December 11, 2018

**RE: MONTGOMERY BLVD. CHURCH OF CHRIST
SITE DEVELOPMENT PLAN FOR SUBDIVISION AND
SITE DEVELOPMENT PLAN FOR BUILDING PERMIT
TRACT A-1, PLAT OF TRACT A-1 KNAPP HEIGHT ADDN
ZONE ATLAS PAGE F-19-Z**

**Conditions of Approval, Site Development Plan for Subdivision
Project # 1011556, Case # 18EPC-40012**

**Conditions of Approval, Site Development Plan for Building Permit
Project # 1011556, Case # 18EPC-40013**

MONTGOMERY CHURCH OF CHRIST 7201 MONTGOMERY BLVD. NE	DRAWN BY BF
	SITE PLAN FOR BUILDING PERMIT	DATE 1/22/19
TIERRA WEST, LLC 5571 MIDWAY PARK PLACE NE ALBUQUERQUE, NM 87109 (505) 858-3100 www.tierrawestllc.com		2016037_SPB
RONALD R. BOHANNAN P.E. #7868		SHEET # C2
		JOB # 2016037

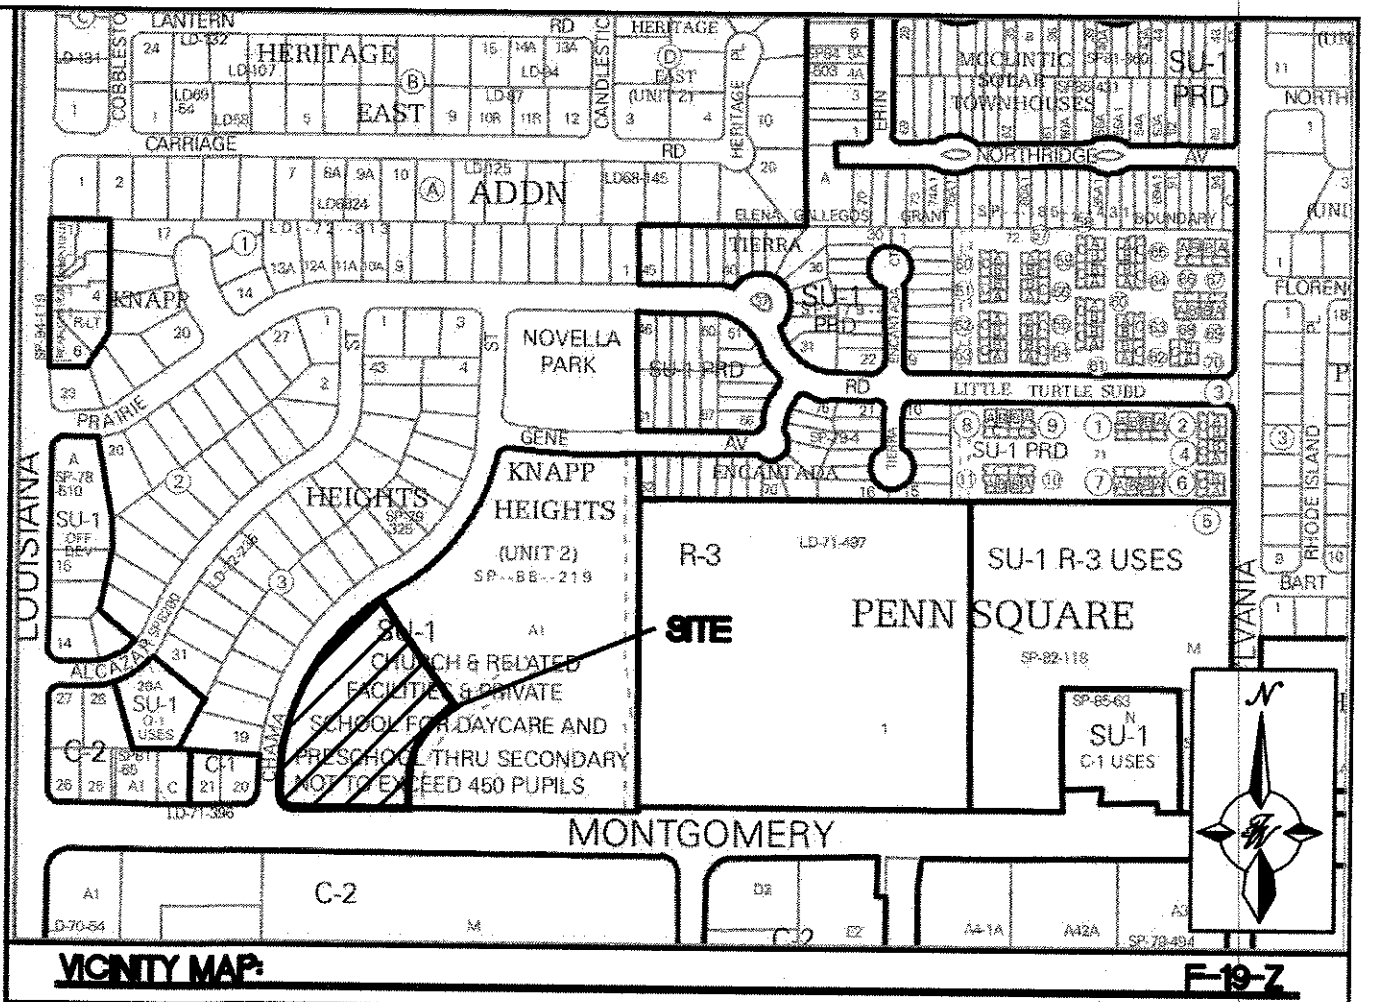
3. Light poles shall be limited 16 feet in height within 100 feet of residential uses.

This note was added to the Site Plan for Subdivision and Site Plan for Building Permit as shown

Sheet Title:
Landscape Plan

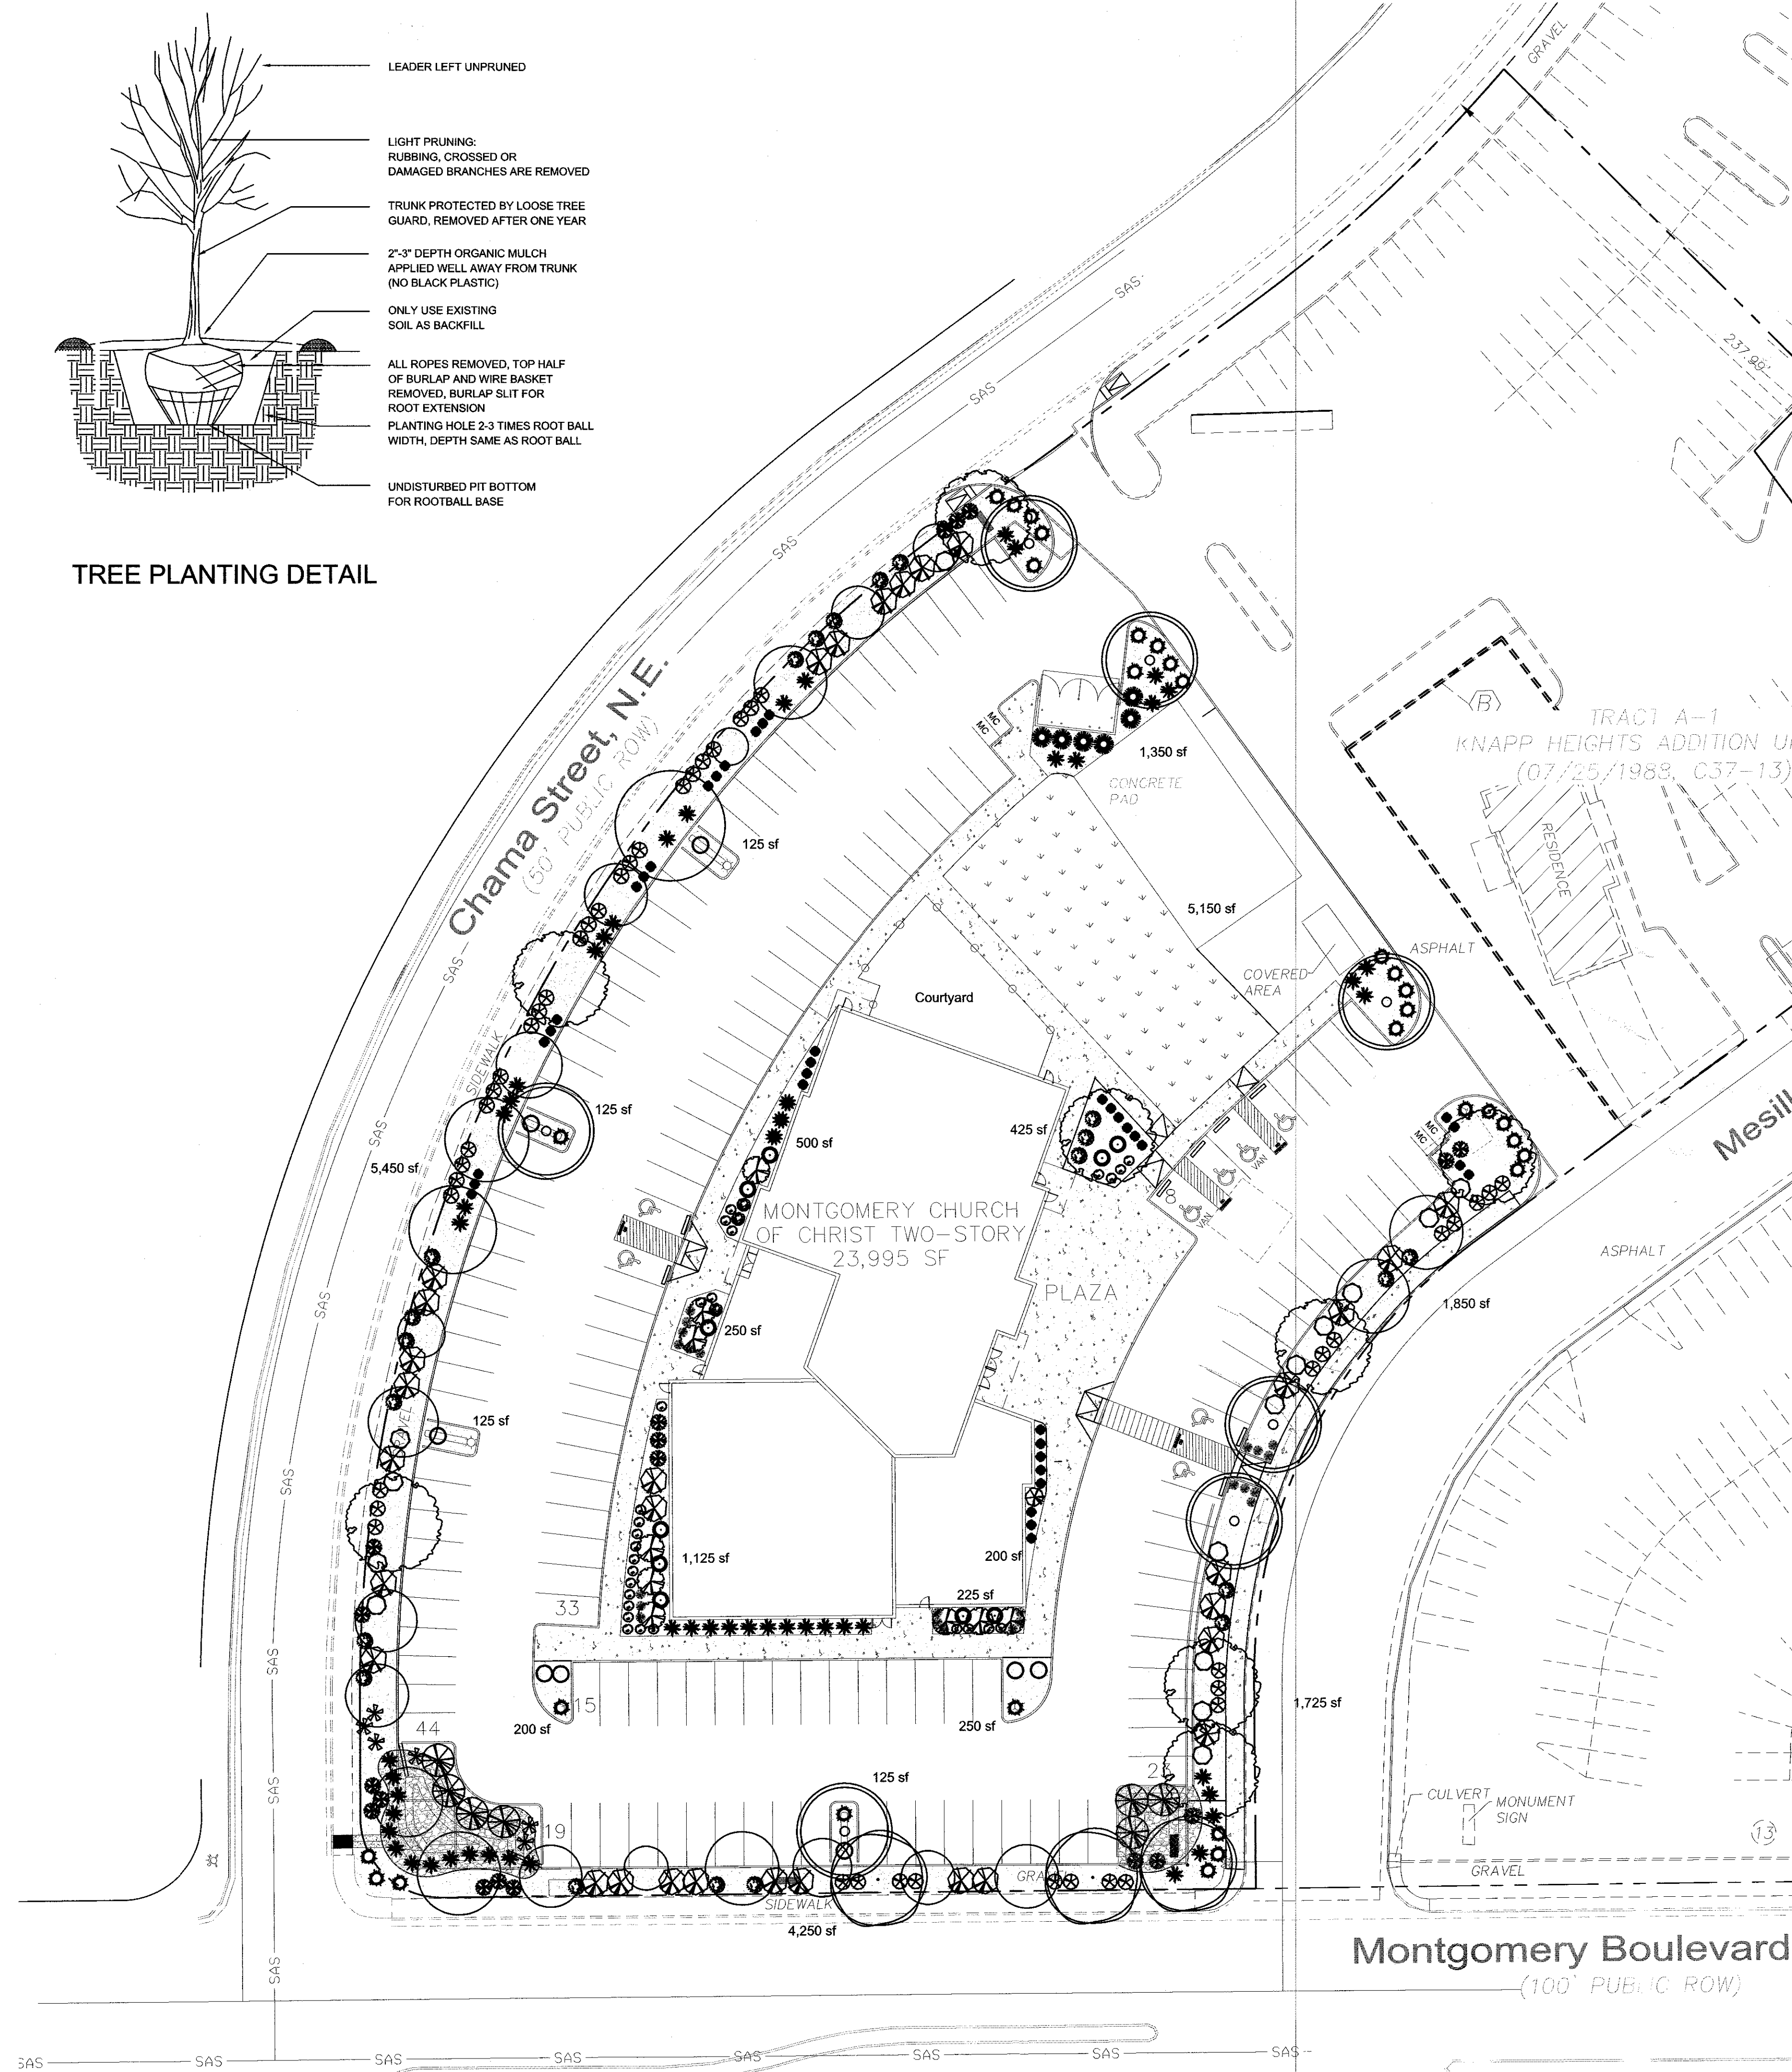
5. Prior to DRB sign off the Blue Mist Spiera will need to be replaced with an evergreen species.

This species was removed and replaced with Indian Hawthorn, as detailed on the landscaping plan.
